Assessment of Likely Landscape and Visual Impacts Arising from: Proposed Replacement Dwelling at Sawley, Application nr 3/2013/0854

By: Steven Brereton, BA Hons, Dip LA, CMLI

Date: 14th January 2014

## LANDSCAPE STRATEGY

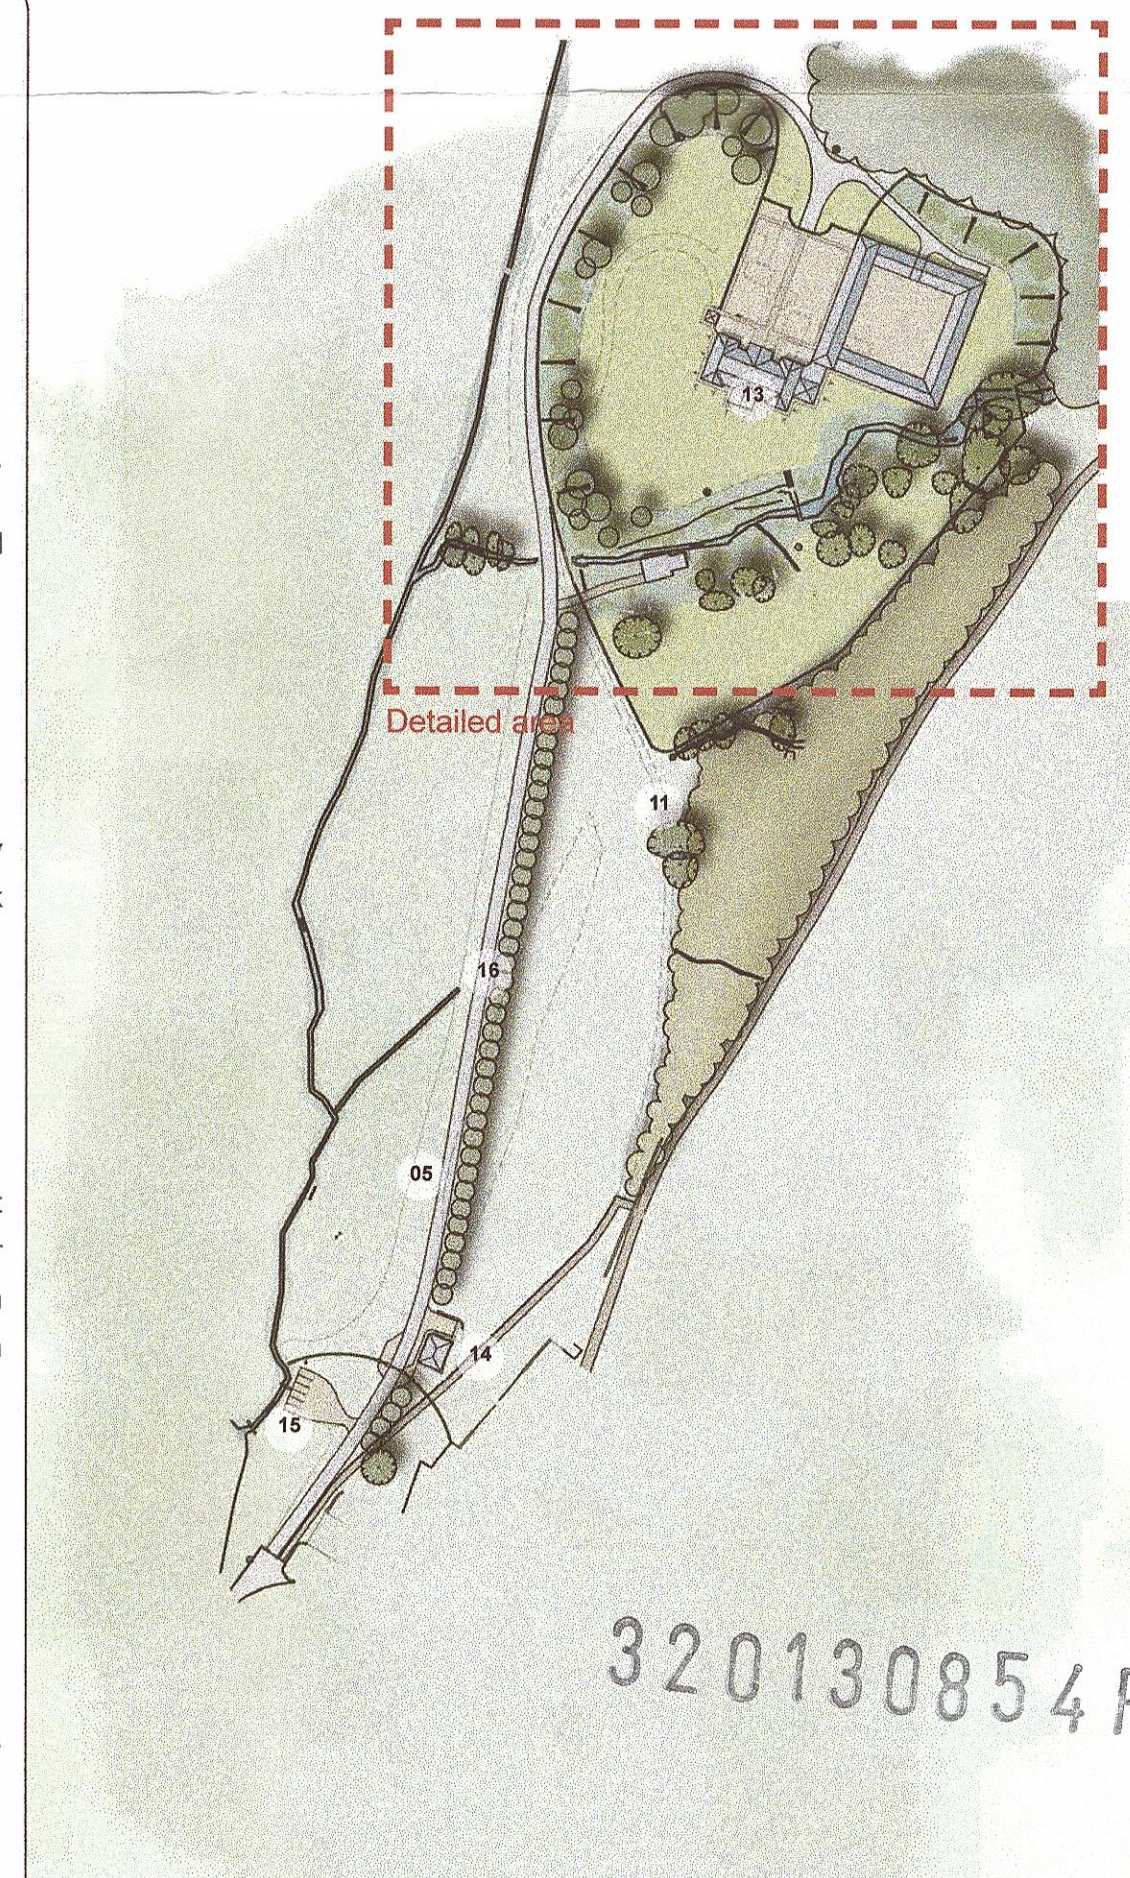
"The substantial proposed boundary wall and bitmac surfaced access road are not shown on any of the Photoviewpoints.

c) No assessment has been made of the likely impacts of the proposed substantial boundary wall. As stated above, it does not even appear on any of the submitted photomontages.

b) the proposed access track would be significantly longer than the one which currently serves the existing house; development in highly sensitive landscapes such as the FOB AONB should seek to conserve the natural scenic beauty. In addition, the proposed track would be situated along the site's western boundary maximising impacts on the valley floodplain and its landscape tranquillity. These effects would be maximal due of course to the boundary location but also due to the inadequate mitigation proposals to the west and east of the track - presumably to ensure that the applicant has views from his property over the valley (which of course maximises the visibility of the proposed house from viewpoints in the valley looking east - south east). By contrast, along the south eastern site boundary a substantial planting buffer is proposed effectively forming an extension of the existing woodland. This suggests to me that the applicant appreciates what is required to adequately mitigate the effects of his proposed development. It is unfortunate that the applicant has failed to recognise the need for such an approach on the site's western boundary.

c) the proposed 2m high 'deer fence' - in reality a substantial boundary WALL - would likely appear as an urbanising structure inappropriate for the area's rural landscape character. Of most concern is the long length of deer fence proposed for the western boundary which as outlined above is within an area that is a real weakness of the proposed scheme.

d) the scale and height of the proposed house and adjoining building is substantial and the site is prominently located on an elevated area near the edge of the flood plain. In addition the proposed mitigation planting on the western boundary – arranged to allow views across the valley and wider landscape from Sawley Hall – would provide only limited mitigation of the building's visual impacts. Consequently, it seems likely that Sawley Hall would be an imposing incongruous man made structure in a rural landscape characterised by built development of a markedly different vernacular style and scale found primarily in scattered cottages and clustered villages.

e) the range of plants chosen for the boundary and avenue planting includes species which are inappropriate for the area either due to their none native origin e.g. *Pyracantha rogersiana*, *Rhododendron* var, *Skimmia* and *Cotoneaster*. Boundary/avenue planting should be comprised of native species which are appropriate for the area's landscape character and

beneficial for local biodiversity. I am not against the use of ornamental plants per se, it's just that they require careful siting in a rural area where the key features of the landscape character are strongly represented. Consequently, I recommend that ornamental plants are situated within the hall grounds away from locations where they would be seen from the wider landscape.
